From: Katie Kurek [REDACTED]
Sent: 05 June 2018 15:15
To: Planning.Responses
Cc: David X Edwards
Subject: RE: Please find attached amendment on planning application Ref: BR/229/17/PL

WEST SUSSEX COUNTY COUNCIL CONSULTATION

TO:	Arun District Council FAO: S Davis
FROM:	Highways, WSCC
DATE:	5 th June 2018
LOCATION:	Land to rear of 41 - 47, Pevensey Road, Bognor Regis, West Sussex, PO21 5NY
SUBJECT:	BR/229/17/PL Erection of 3 No. dwellings, 1 No. detached garage, parking & alterations to existing access & driveway (resubmission following BR/200/16/PL).
RECOMMENDATION:	
S106 CONTRIBUTION TOTAL:	£N/A

Cycle store detail

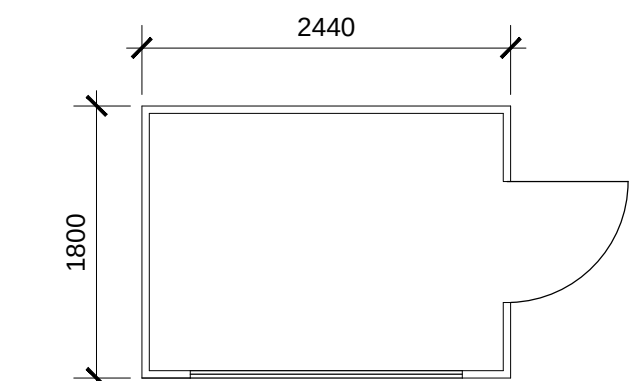
No part of the development shall be first occupied until covered and secure cycle parking spaces have been provided in accordance with plans and details submitted to and approved by the Local Planning Authority.

DRAWING TITLE	
Block & Location Plans and Site Section	
DATE	SCALE
Feb 18	1:200 @ A1
JOB NO.	DRAWING NO.
1615	2.13
	CHECKED BY
	REVISION
	DRAWN BY
	GIM

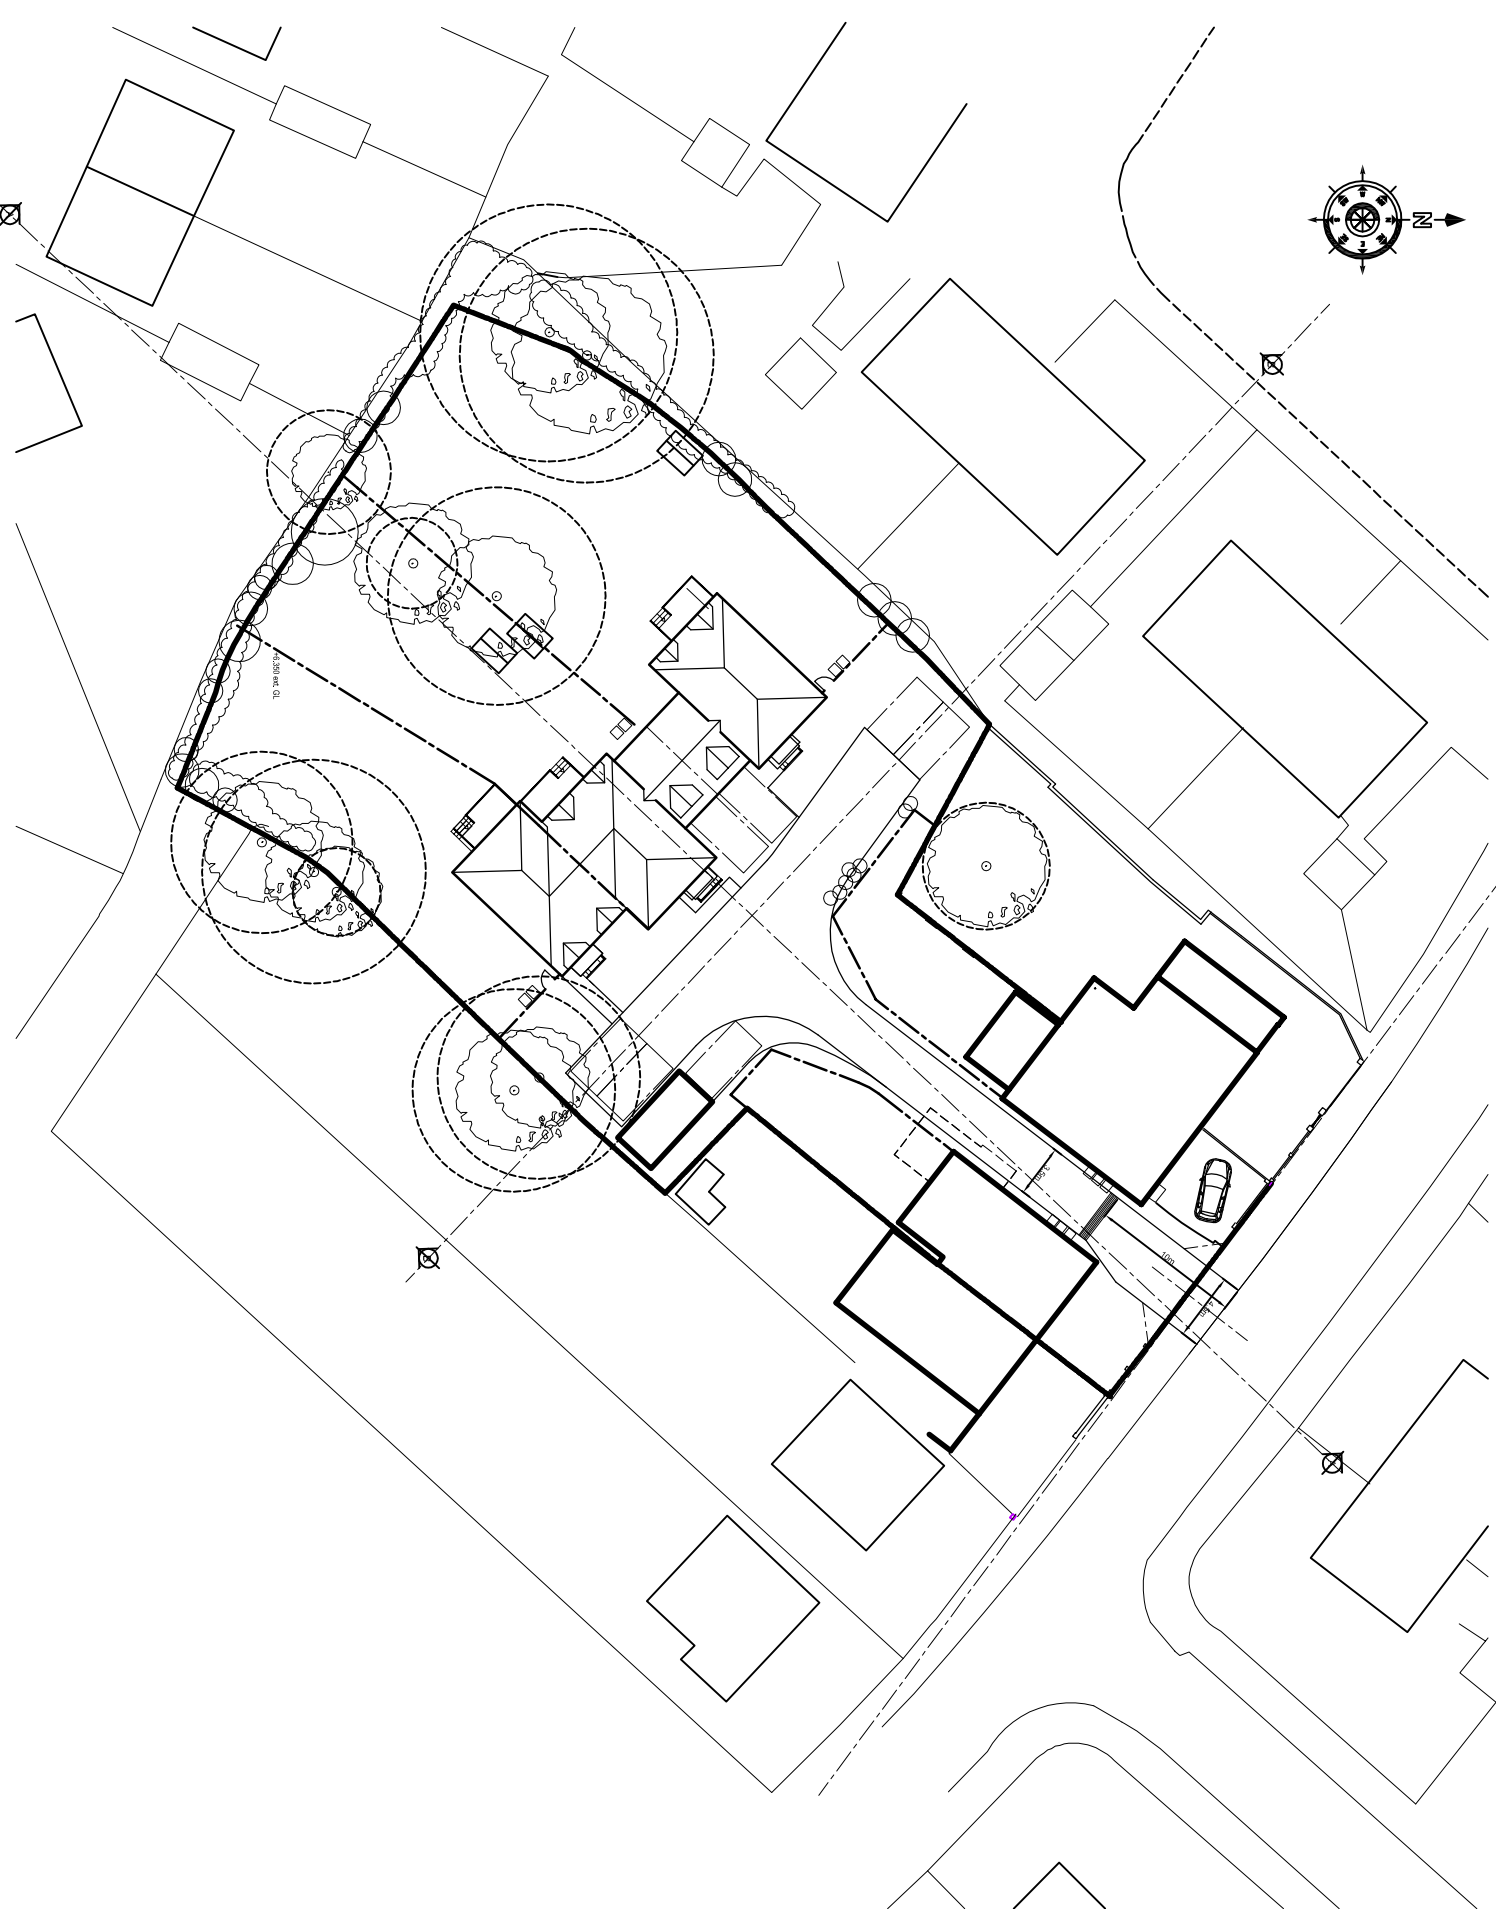
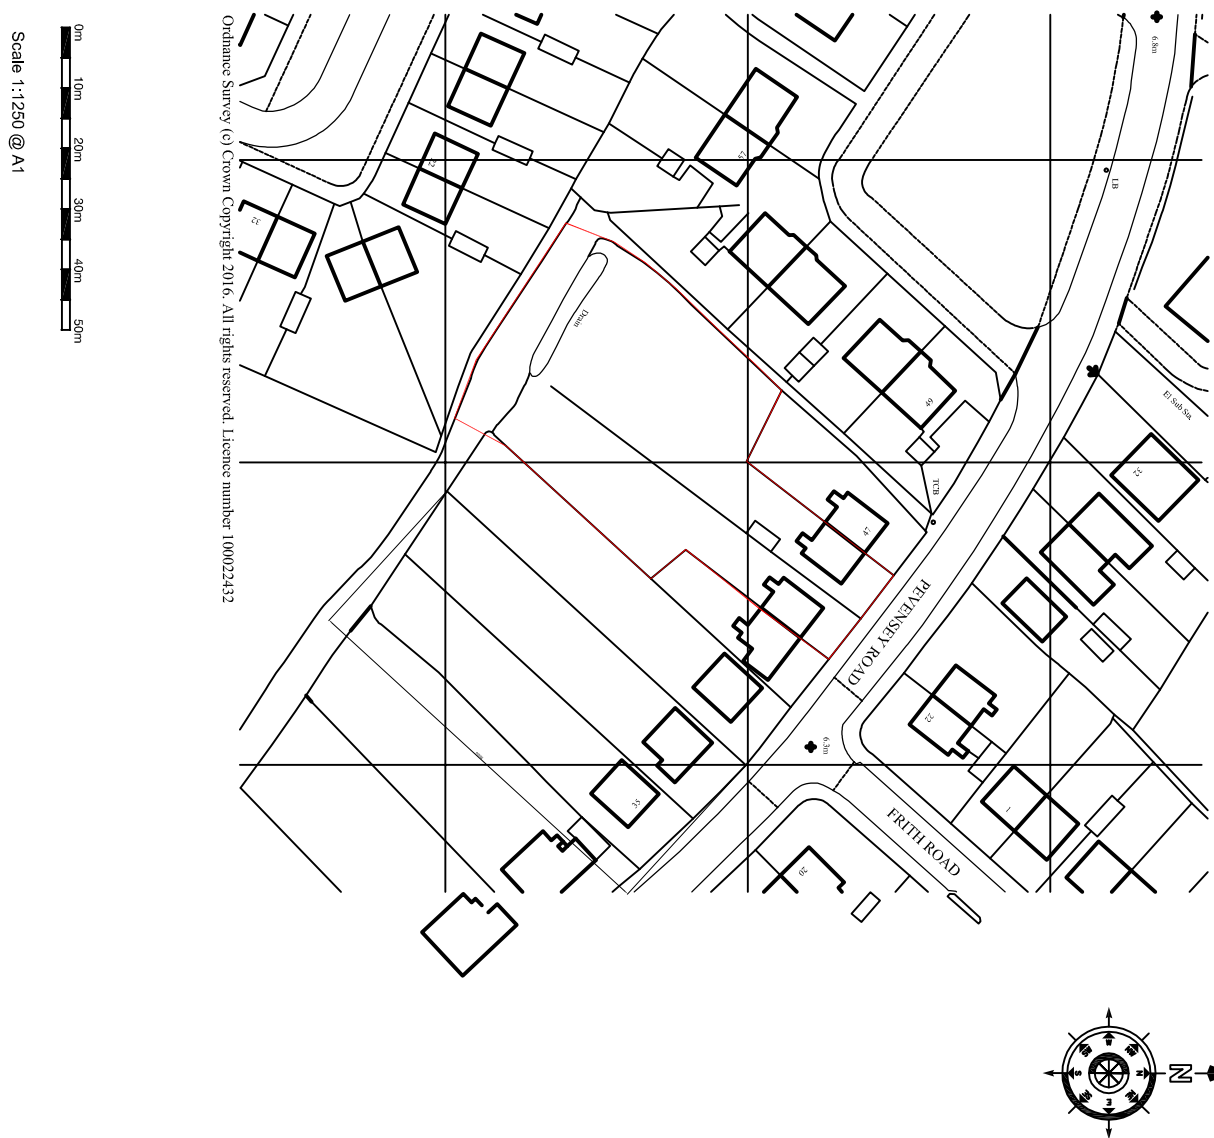
The applicant has demonstrated that the amended internal layout can still accommodate a fire appliance turning on site to exit onto Pevensey Road in a forward gear. Previous comments to access and visibility should be referred to, and conditions advised therein.

No part of the development shall be first occupied until pedestrian visibility splays of 2 metres by 2 metres have been provided either side of the site vehicular access onto Pevensey Road in accordance with the approved plan. These visibility splays shall thereafter be kept free of all obstructions over a height of 0.6 metre above adjoining carriageway level or as otherwise agreed.

No part of the development shall be first occupied until the vehicle parking and turning spaces have been constructed in accordance with the approved plan. These spaces shall thereafter be retained for their designated use.
